Re: Juan Tabo Hills Request for CLOMR Response to Comments (Project # 1005278)

Below, please see our response to your comments dated April 8, 2015 for our request for CLOMR for Juan Tabo Hills Estates.

NOTE:
SHOTCRETE 12" BELOW GRADE AND LOWER TO BE 1:1 SLOPE. SHOTCRETE ABOVE 12" BELOW GRADE TO BE 2:1 SLOPE. SEE SECTION G ON SHEET 19

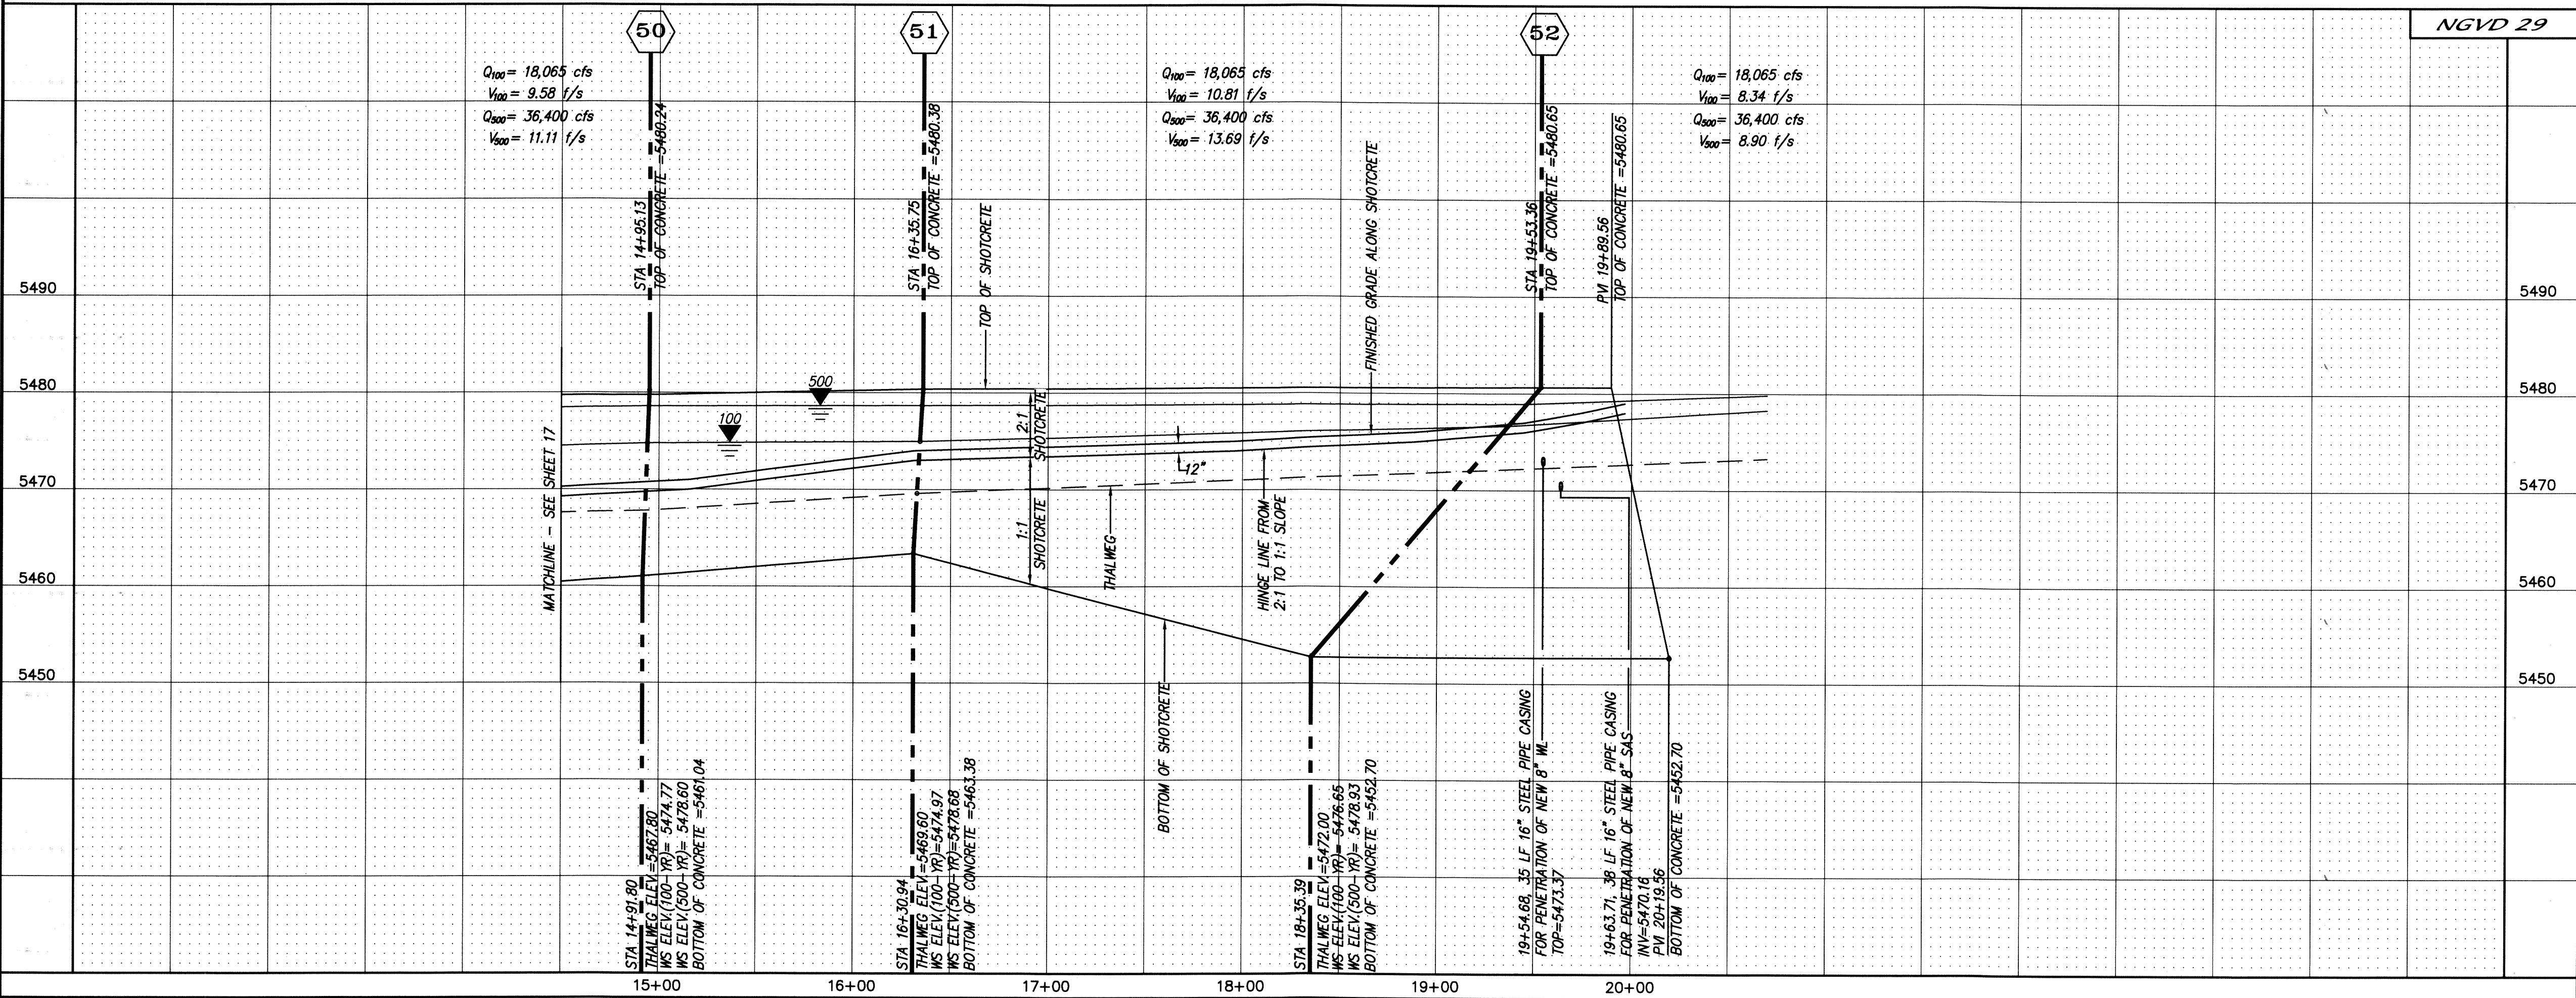
10. Provide a plan showing river station stationing. **The stationing is shown on the Bank Protection Plan and Profile. That stationing match the HEC-RAS model.**
